Report following a request for further information or negotiation

REF NO: BE/23/14/PL

LOCATION: Adjacent Warehouse site to
McDonalds
Oldlands Way, Bersted

PROPOSAL: Change of use from Class B8 (Storage or Distribution) to Class A1 (Shops)
including partial demolition

Site Plan as Proposed
Single Unit Option

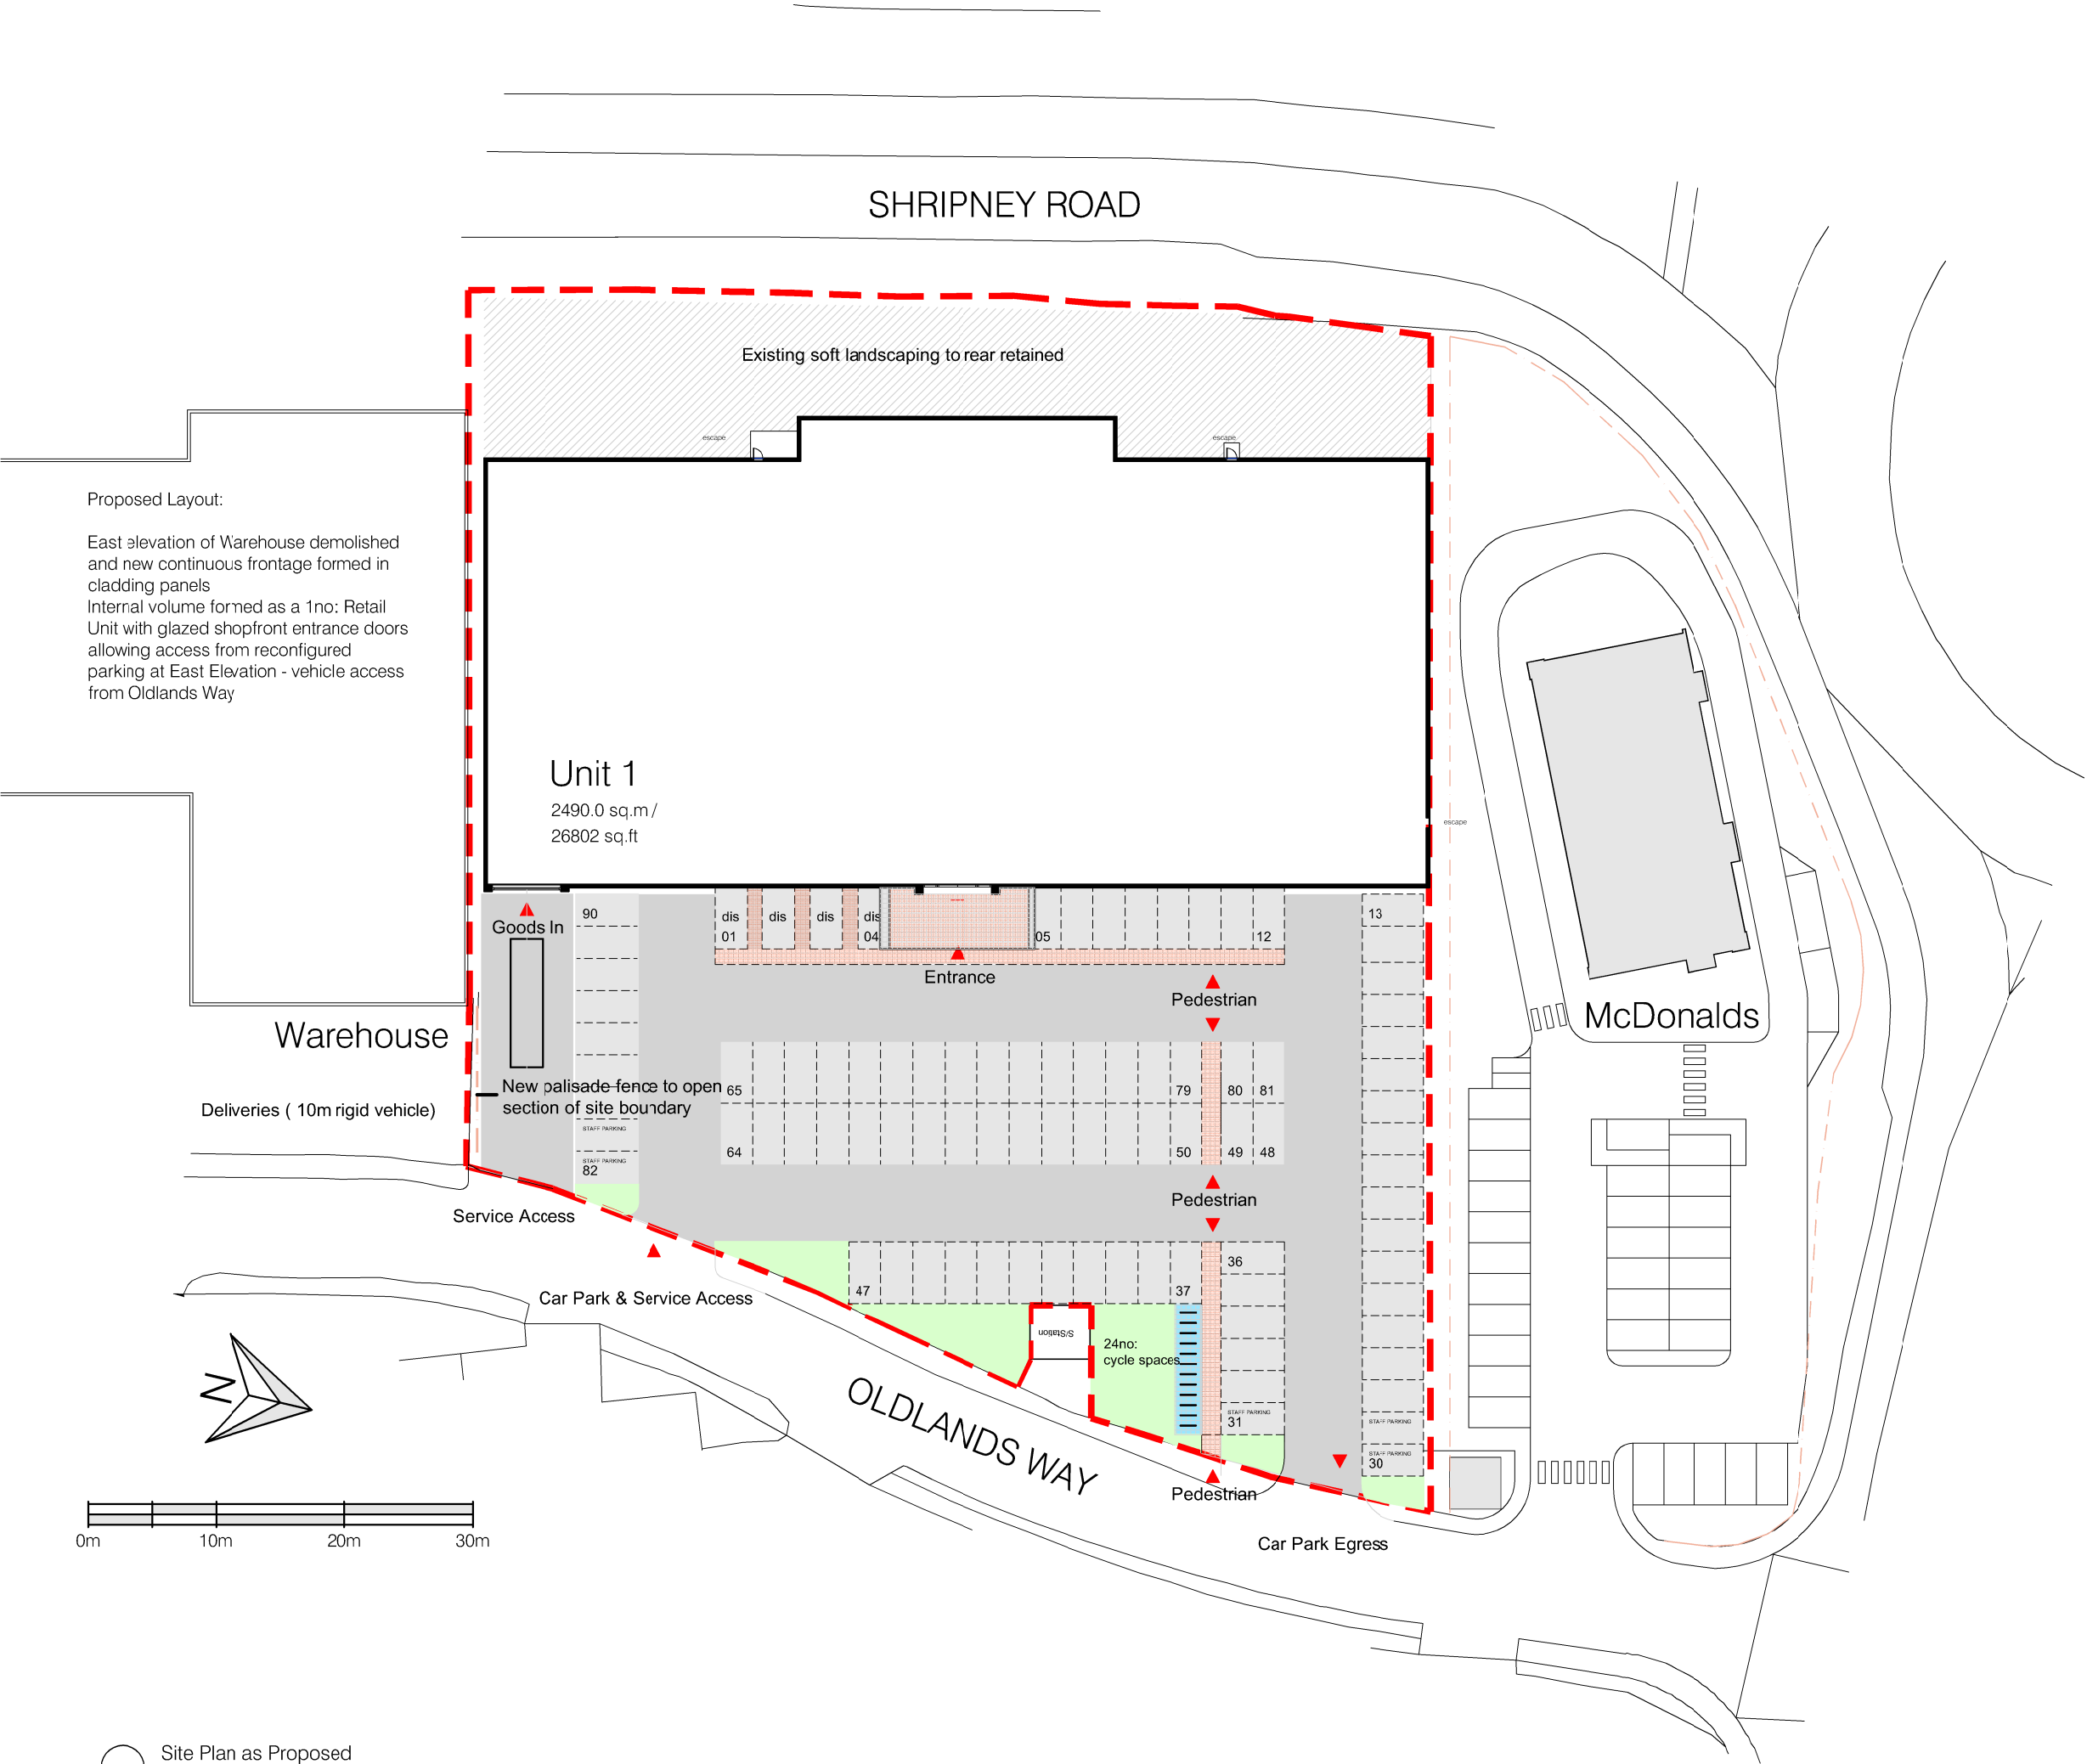
However, members should also note that an amended site plan has been received which omits the proposed hardstanding and green palisade fence to the rear of the building. This amendment is reflected in the list of plans in condition 02 below.

The retail store shall not be occupied unless and until space has been laid out within the site in accordance with drawing Ref 593-PL(00)013 Rev B (01/10/14) for the parking of customer cars, staff cars, disabled vehicles & bicycles, for the loading & unloading of delivery vehicles and for vehicles to turn so that they may enter and leave the site in forward gear. The approved parking and turning areas shall thereafter be retained for the approved use.

(2) In respect of proposed condition 07, the applicant pointed out that the submitted plans show that delivery vehicles will reverse into/out of the site. Therefore, it has been agreed with WSCC Highways that the condition be amended to make it clear that the turning facilities are only in respect of passenger vehicles. The condition is amended by the insertion of the word passenger as per the following:

The retail store shall not be occupied unless and until space has been laid out within the site in accordance with drawing Ref 593-PL(00)013 Rev B (01/10/14) for the parking of customer cars, staff cars, disabled vehicles & bicycles, for the loading & unloading of delivery vehicles and for passenger vehicles to turn so that they may enter and leave the site in forward gear. The approved parking and turning areas shall thereafter be retained for the approved use.
